Our Ref: 211379 - Let 1 - Aldingbourne

16 June 2021

Re: Tree issues at land at Springfield Hook Lane, Aldingbourne, PO20 3TE

I write with regard to my recent instruction concerning the above project. You asked me to visit the site, review the tree protection regime in place at that time and then provide comments on the protection measures in terms of positioning and appropriateness.

Title:-
Proposed Hedgerow Protection Plan

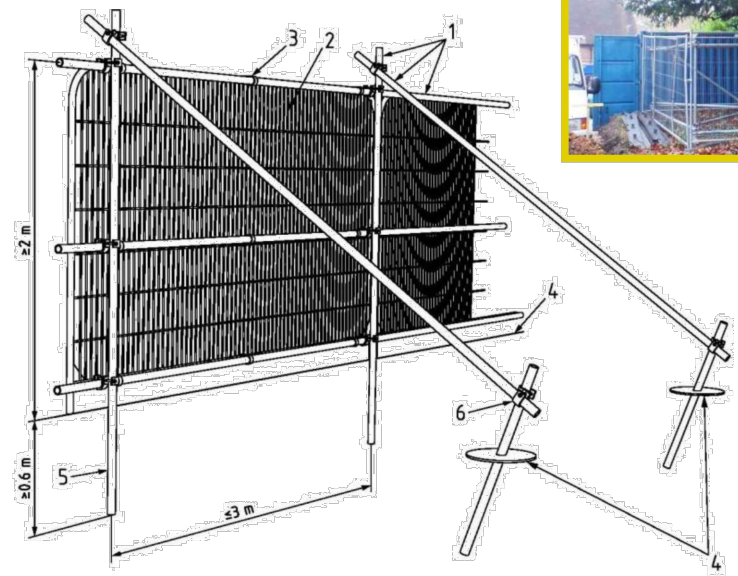
Prior to visiting, I prepared a drawing (see attached plan 'ECO 1') which was an adapted version of the Vivid Design Studio Proposed Hedgerow Protection Plan. This drawing included dimensions relevant to the tree protection barriers and was issued to assist site operatives in positioning the barriers in accordance with the Vivid Design Studio drawing. I visited the site on 14 June 2021 to assess the tree protection measures being implemented at that time and during my visit I took a number of photographs, some of which I have appended to the end of this report for reference.

The erection of the tree protection barriers was ongoing when I visited, but was nearing completion (photograph 1). I observed and sample checked the barrier positions on site using a laser measuring device against the dimensioned drawing that I had prepared previously. I noted that the barriers appeared to be generally in the positions shown on the tree protection plan. Where significant trees were growing along the northern site boundary, the weld mesh panels were appropriately braced with a vertical and horizontal scaffold framework and rear facing stabiliser struts (photograph 2).

Where there were less significant trees (or areas of scrub), then a lesser specification was being utilised, which incorporated mesh panels on rubber block trays, with rear facing stabiliser struts pinned in position (photograph 3). Tree protection notices were being attached to the panels during my visit (photograph 4). The tree protection barriers on the eastern site boundary (and where trees have been removed previously) appeared to be in roughly the correct positions, but the protection consisted of weld mesh panels placed on their rubber block trays.

In my view, the tree protection I noted on site is adequate in terms of protecting the more important trees during the construction phase. The two types of barriers I observed would be broadly in line with figures 2 and 3 set out in *BS 5837:2012 Trees in relation to design, demolition and construction – Recommendations*. Consequently, I would suggest that you now contact the councils Tree Officer, send him a copy of this report and seek his views on whether he is content with the tree protection measures shown. However, I would draw your attention to condition 5 (as set out in the Decision Notice) which requires ongoing site monitoring and supervision to ensure that the provided tree protection remains ‘fit for purpose’ during the construction phase.
